Project Name SILVER STREET TOWNHOMES

2. **Project # 1003585**

05DRB-01925 Major-Vacation of Public Easements

05DRB-01926 Minor-Prelim&Final Plat Approval

**PLAT OF
LOTS 1-A-1, 10-A-1, 11-A-1 & 20-A-1
SILVER STREET TOWNHOMES**

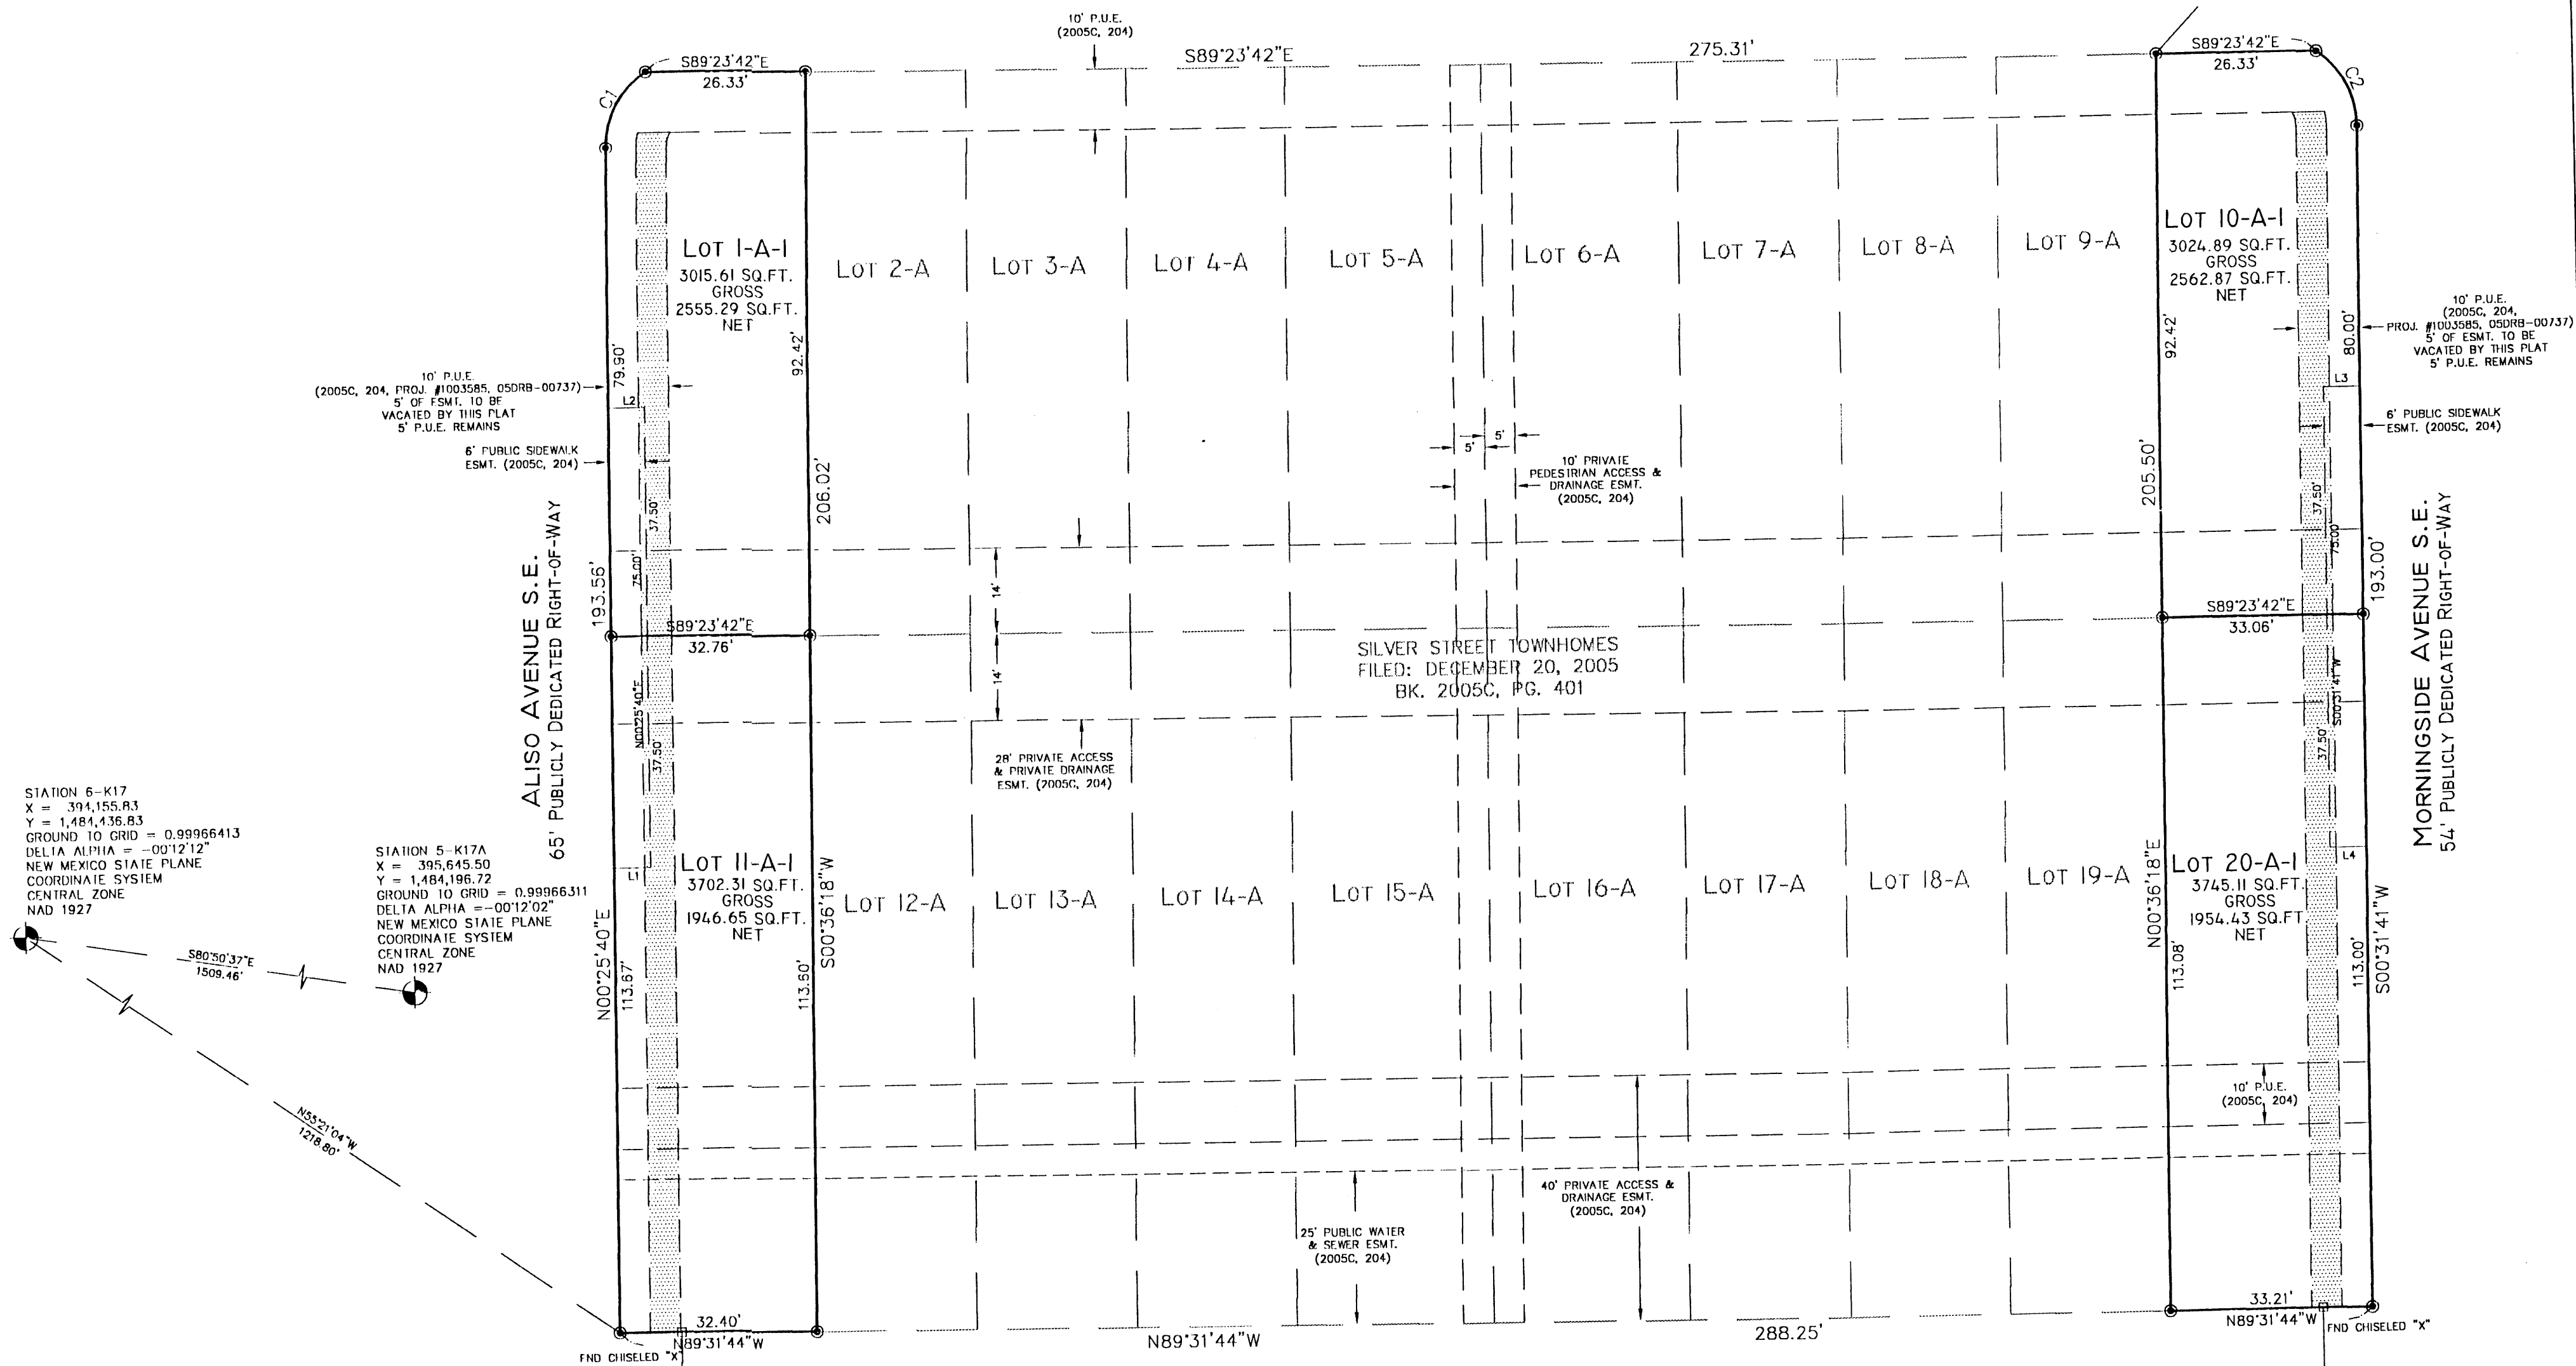
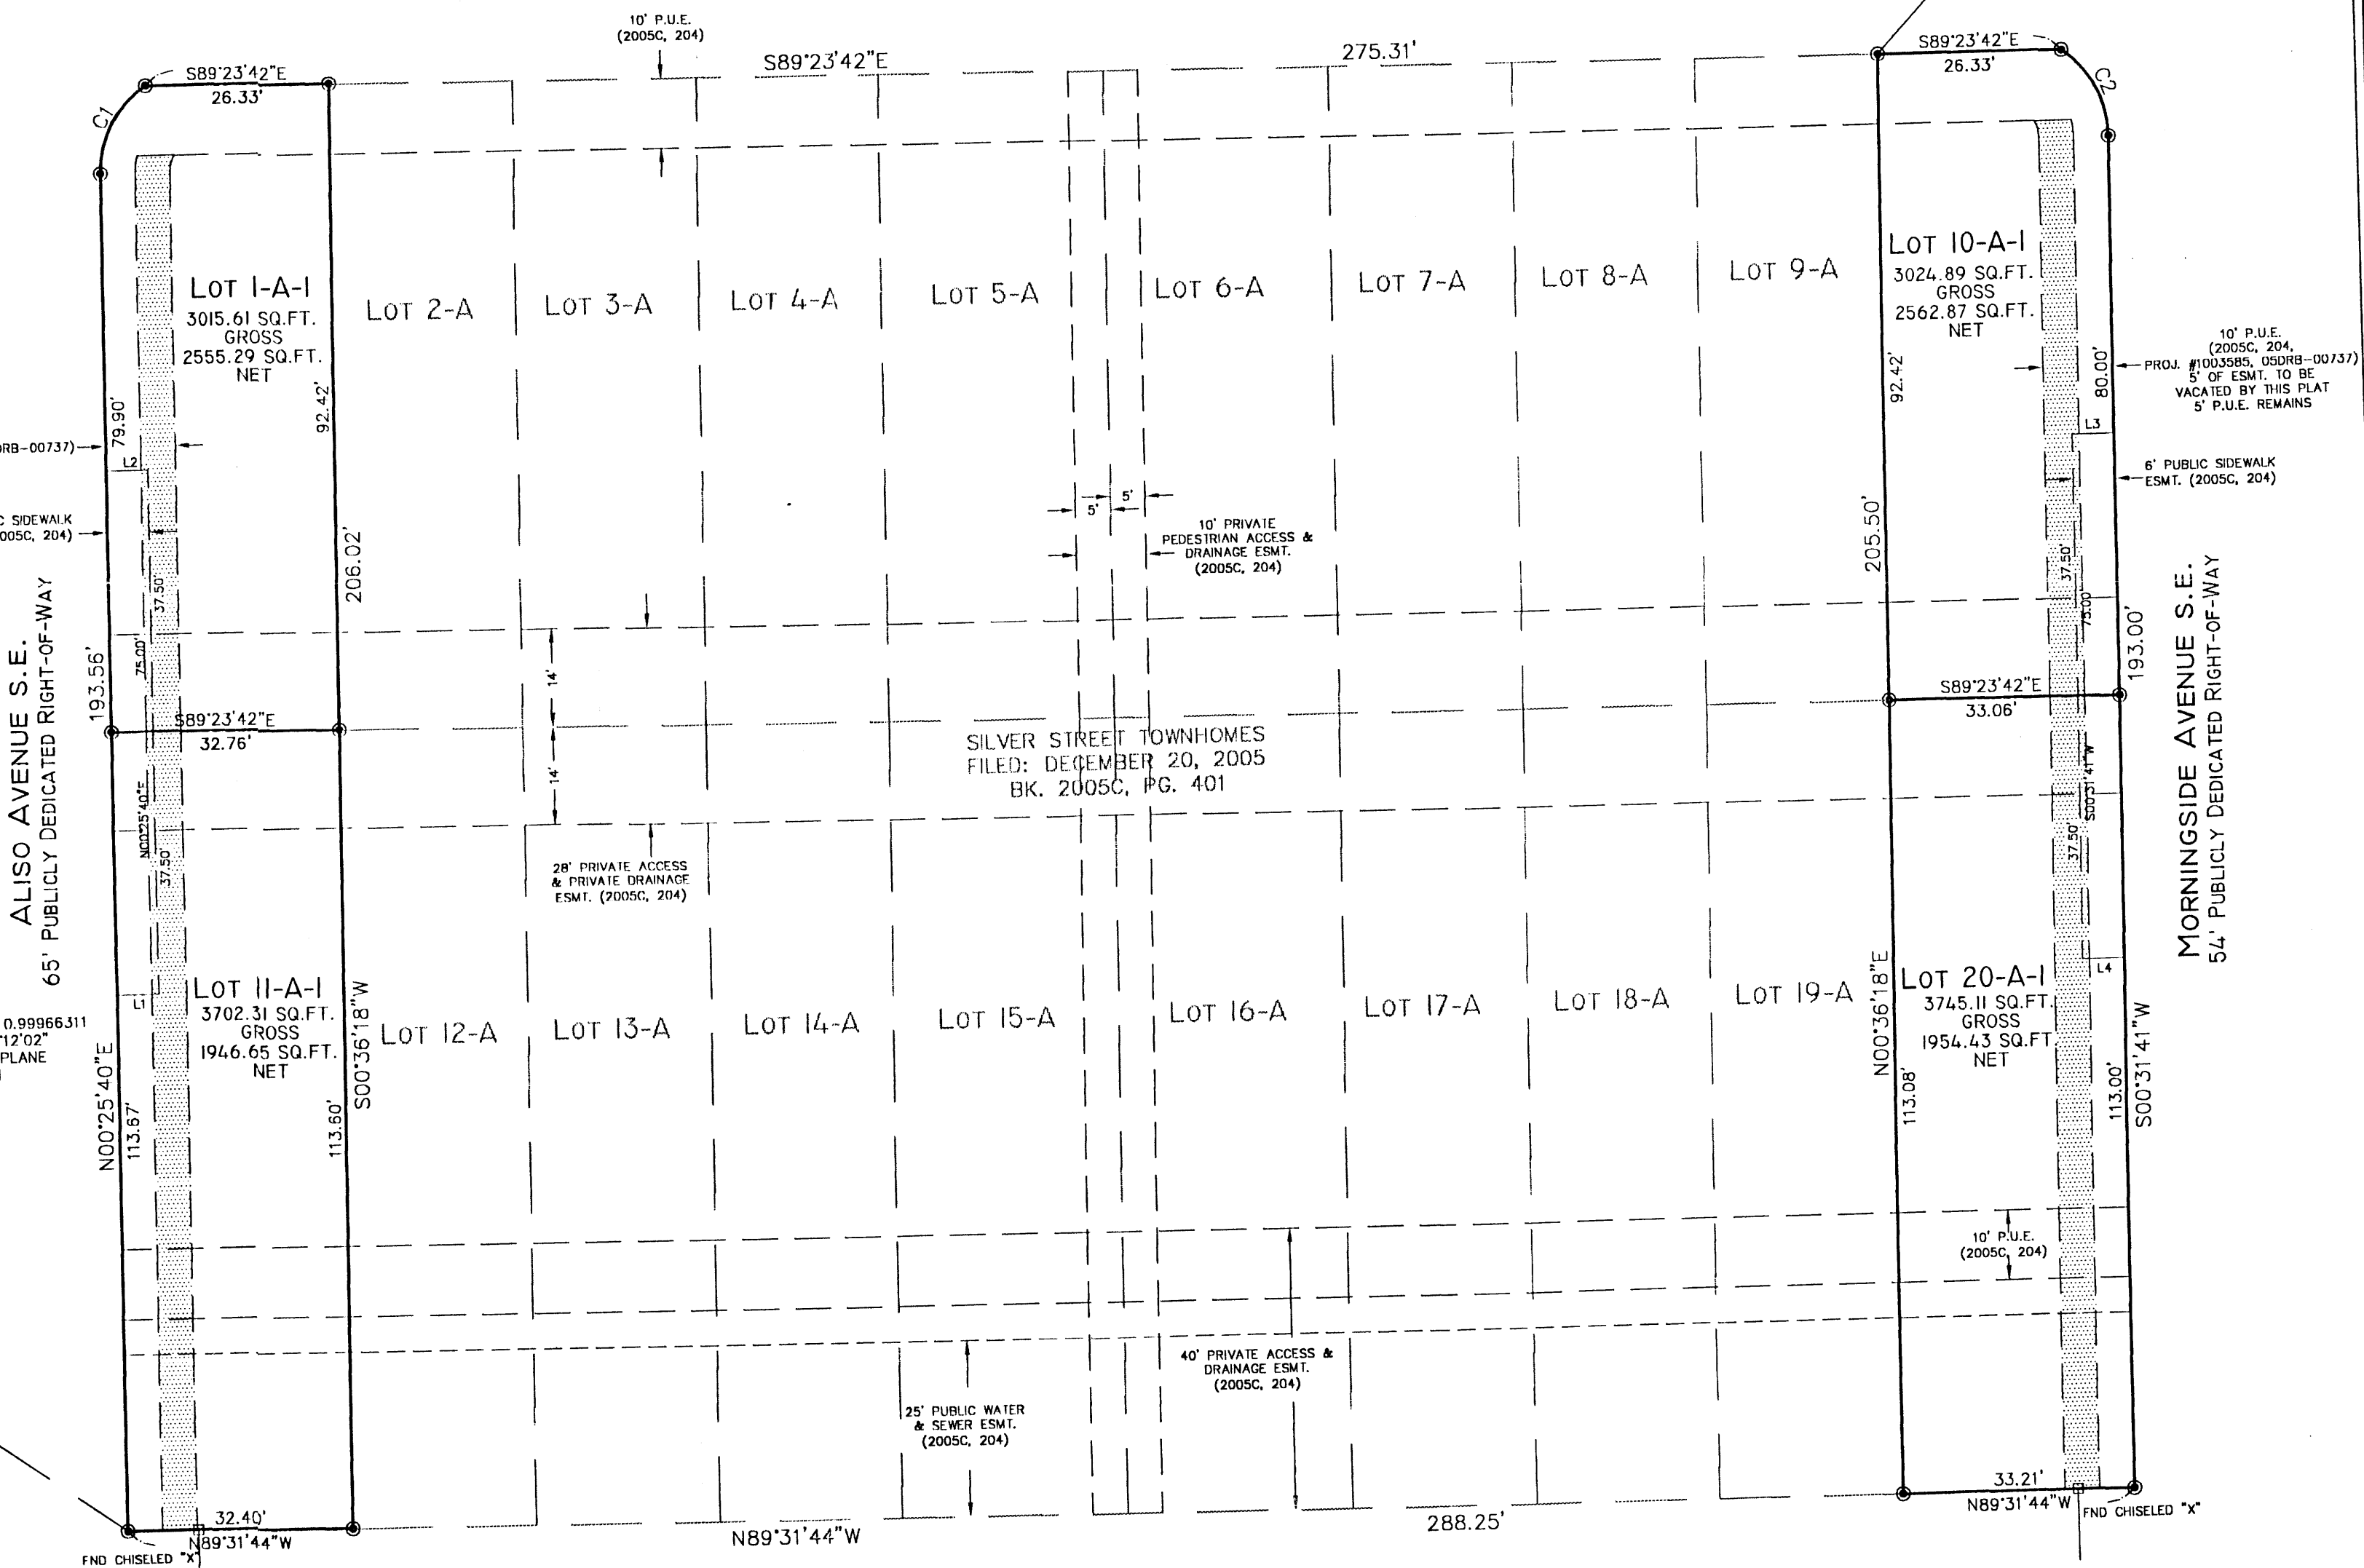
This request is **not approved**, there are existing PNM facilities in the easement including gas service lines. Will there be in easement, after vacation? Contact Fernando Vigil. R/W Agent at 241-4434 e-mail – fvigil@pnm.com

Unsure where the utilities will be located? Are the private utilities in favor of this vacation request? We need their concurrence before the action is approved.

There is an existing 24" sanitary sewer line that is located in this parcel of I and.

As a condition of final plat: The applicant/agent must show the location of the existing manhole and the location and depth of the existing 24" sewer line to determine the impact of this proposed platting action.
